January 17, 2020

RE: Hope Works Hope Village 1215 3rd St. NW Grading and Drainage Plan Stamp Date: 1/16/20 Hydrology File: J14D194

PO Box 1293 Based on the submittal received on 1/16/20, the above-referenced grading and drainage plan is approved for Plat.

TITLE GRADING PLAN

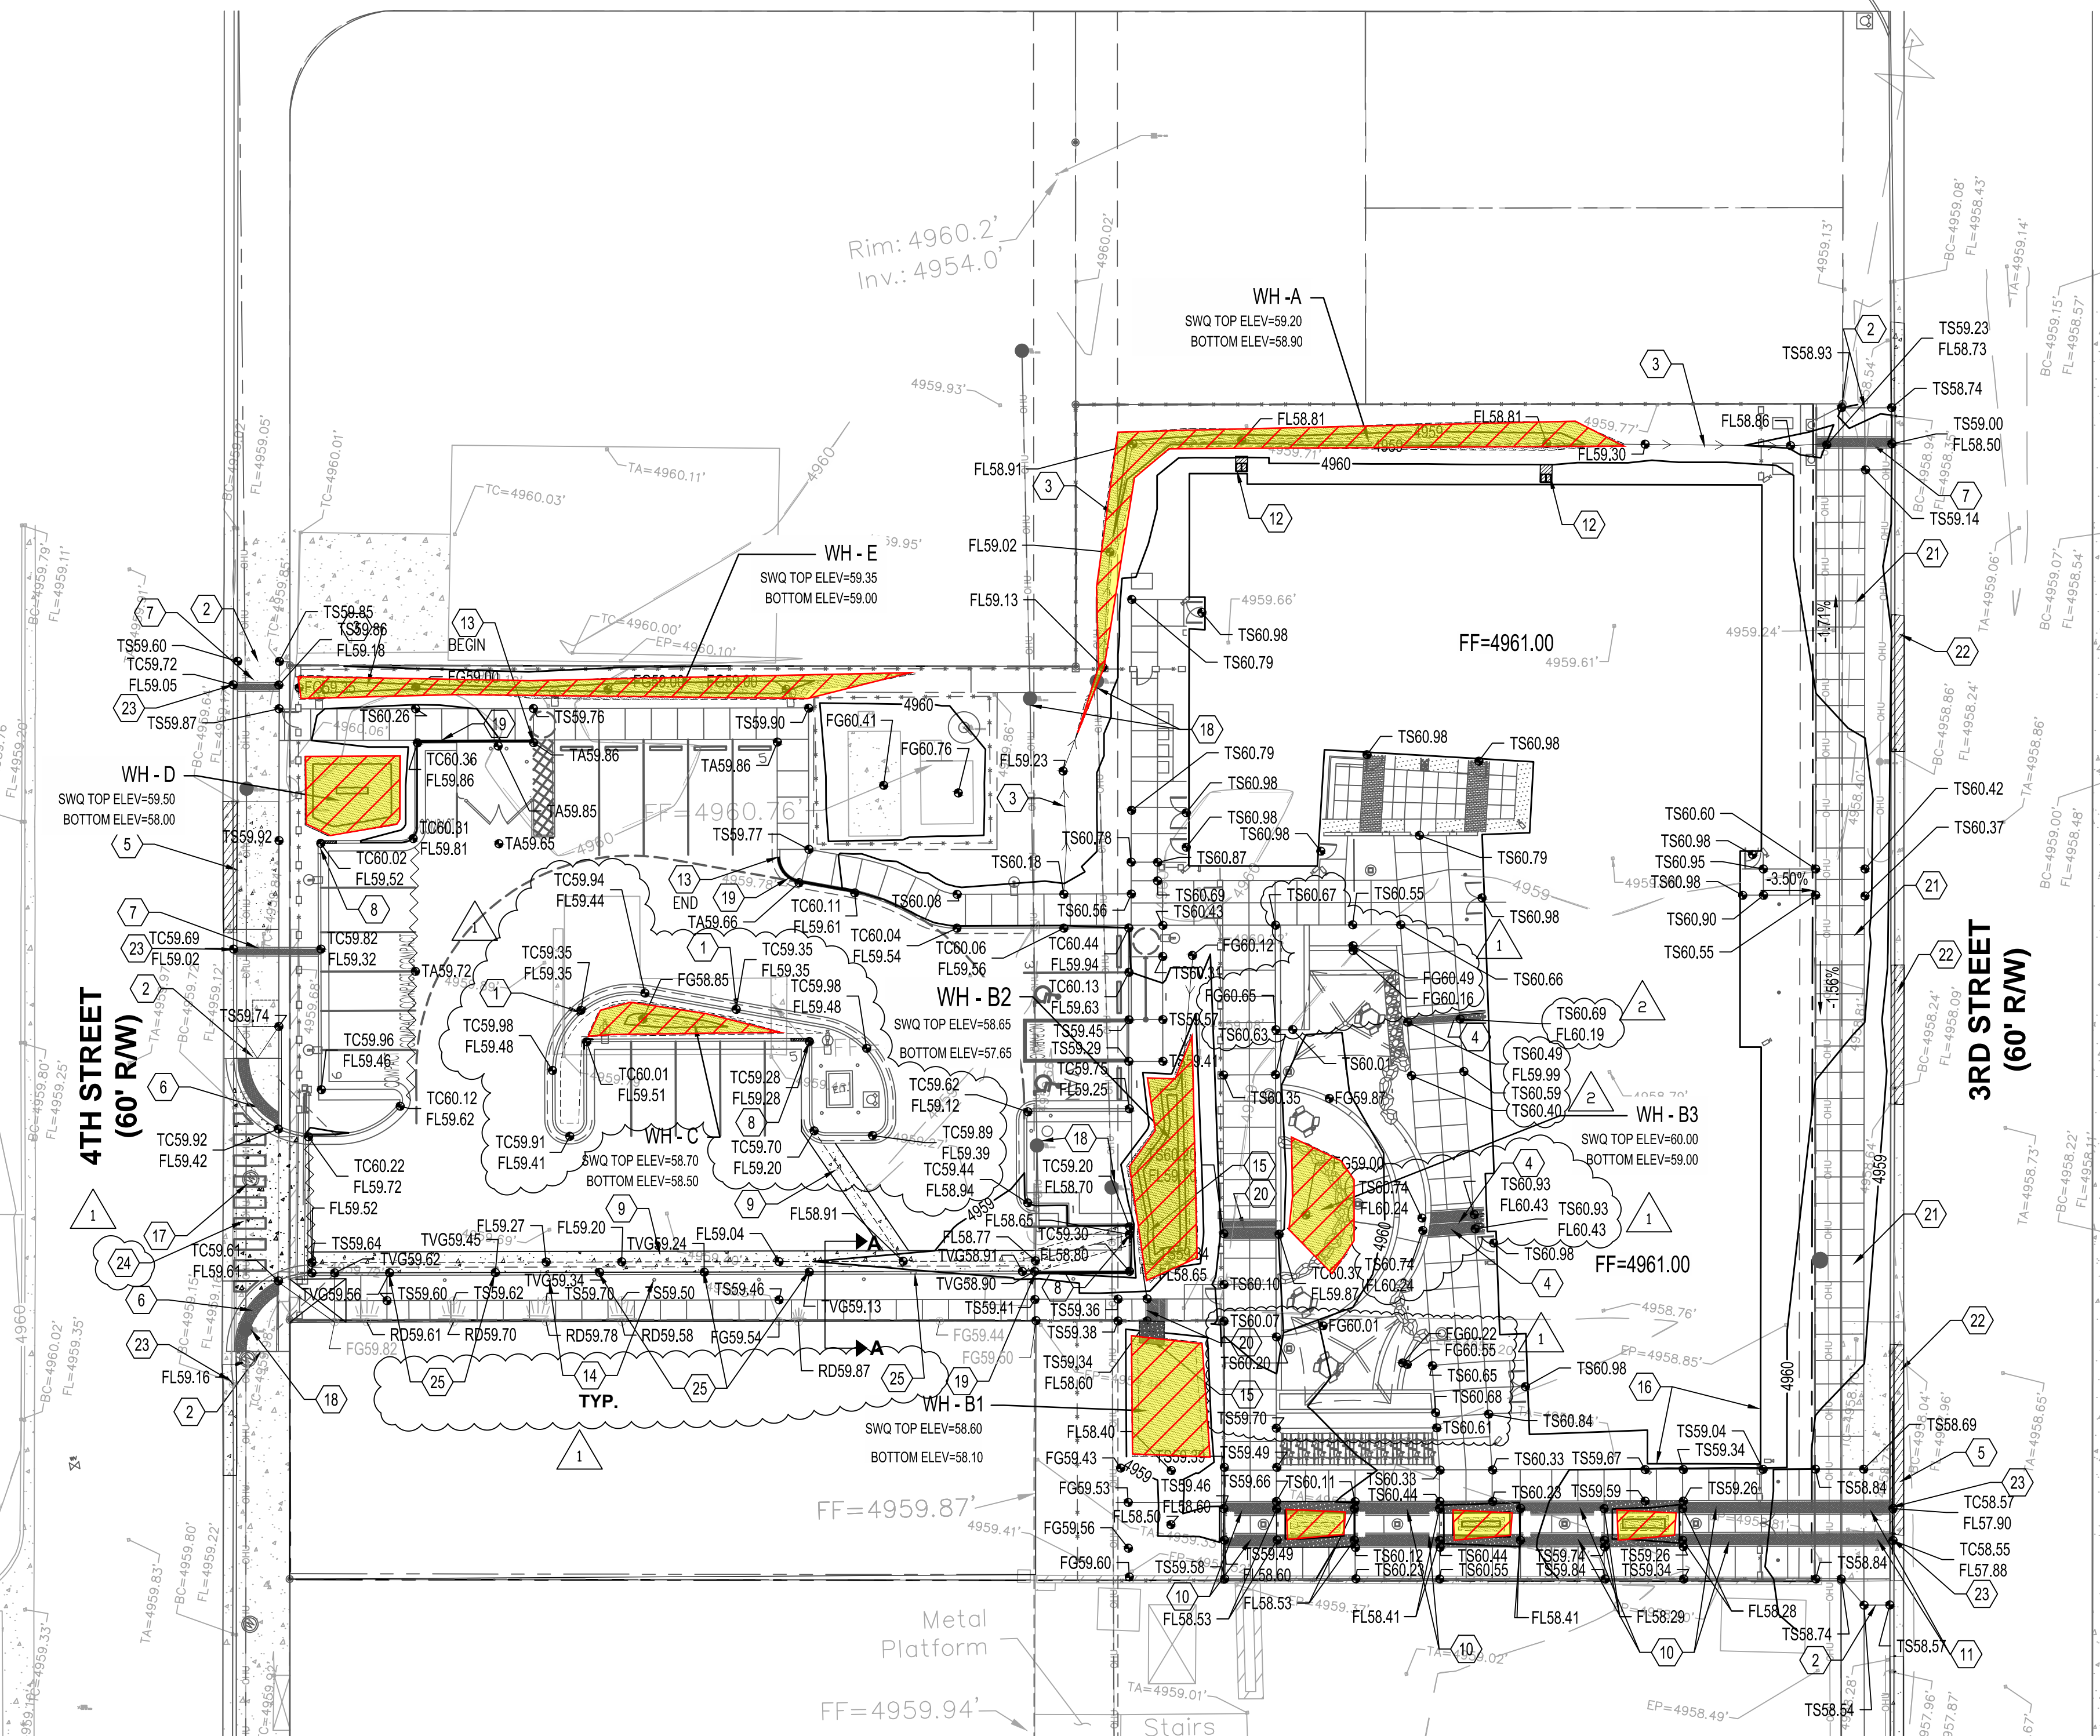
- Albuquerque 1. Remove any "Conceptual" markings.
 - 2. Include project benchmark and datum; all existing survey, proposed grades, and benchmarks must be provided in NAVD 88.
 - 3. Since the site is extremely flat, please provide existing and proposed spot elevations in enough density to verify the drainage areas and outfalls that you have indicated.
